July 3, 2014

**Subject: 421 Warren Avenue
Final Site Plan Application/Delegated Review Stormwater
Conformance with Standards
Comment Response #3**

REV	DATE	DESCRIPTION	REVISIONS
3	07.03.14	FINAL PLAN SUBMISSION TO CITY PER CONDITIONS OF APPROVAL	
2	04.17.14	FINAL PLAN SUBMISSION TO CITY	
1	02.10.14	SUBMITTED TO CITY OF PORTLAND

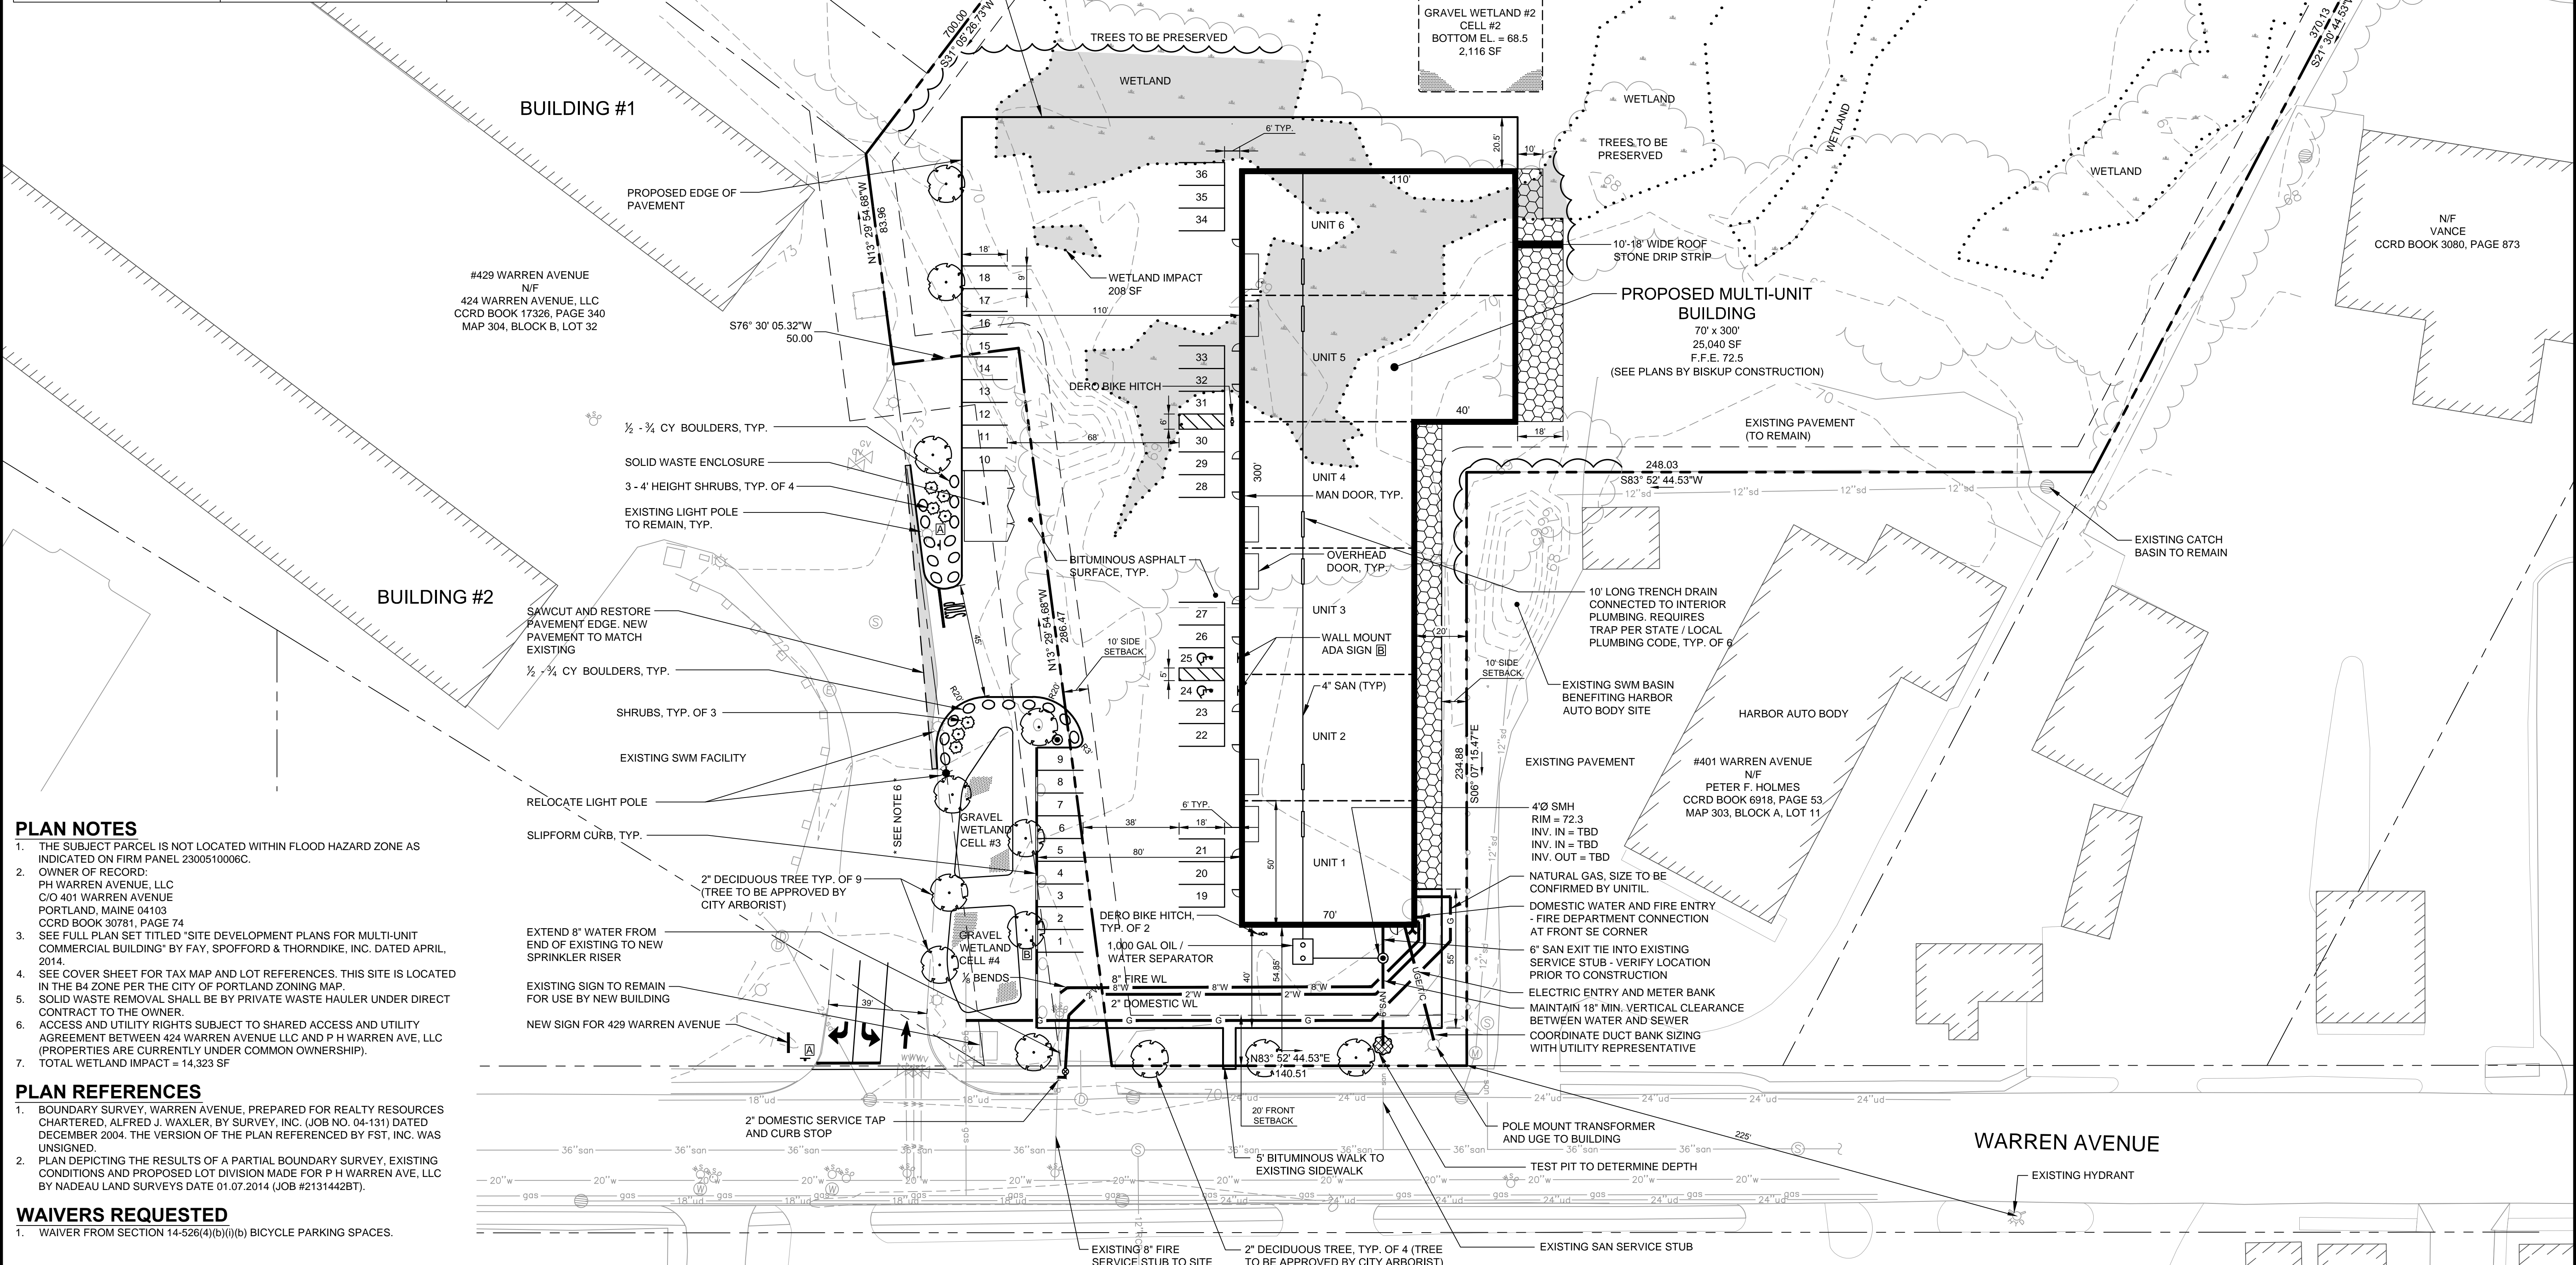
That the applicant shall submit a Landscape Plan, based on a submitted assessment of the trees on the site, that shows the following: tree saves; any required replacement planting; and additional planting; snow storage areas; all to address the landscape preservation and parking lot landscaping requirements of the Site Plan Ordinance (14-526), for review and approval by the Planning Authority and City Arborist; and

The accompanying plan includes additional measures intended on satisfying this condition. This includes supplemental plantings around the site.
